CITY OF ALBUQUERQUE

**Re: Lindo Mexico Addn.
7209 Central Ave NE
30-Day Temporary Certificate of Occupancy
Transportation Development Final Inspection
Engineer's/Architect's Stamp dated 5-20-19 (K19D144)
Certification dated 1-8-20**

SIGN 'A'

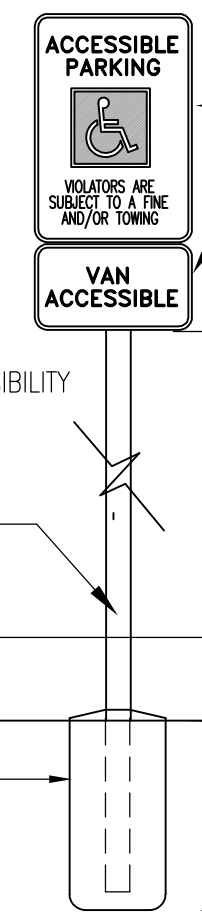
- Please label the 4 small cars stalls. Label the compact parking spaces by placing the words "**COMPACT**" on the pavement of each space.
- Please add bicycle rack.
- Please add motorcycle signs. Each Motorcycle parking space shall be designated by its own conspicuously posted upright sign, either free-standing or wall mounted per the IDO.
- Please add to ADA access aisles. The ADA access aisles shall have the words "**NO PARKING**" in capital letters, each of which shall be at least one foot high and at least two inches wide, placed at the rear of the parking space so as to be close to where an adjacent vehicle's rear tire would be placed. (66-1-4.1.B NMSA 1978)
- Please update ADA signs. The ADA accessible parking sign must have the required language per 66-7-352.4C NMSA 1978 "**Violators Are Subject to a Fine and/or Towing.**" Please call out detail and location of HC signs.
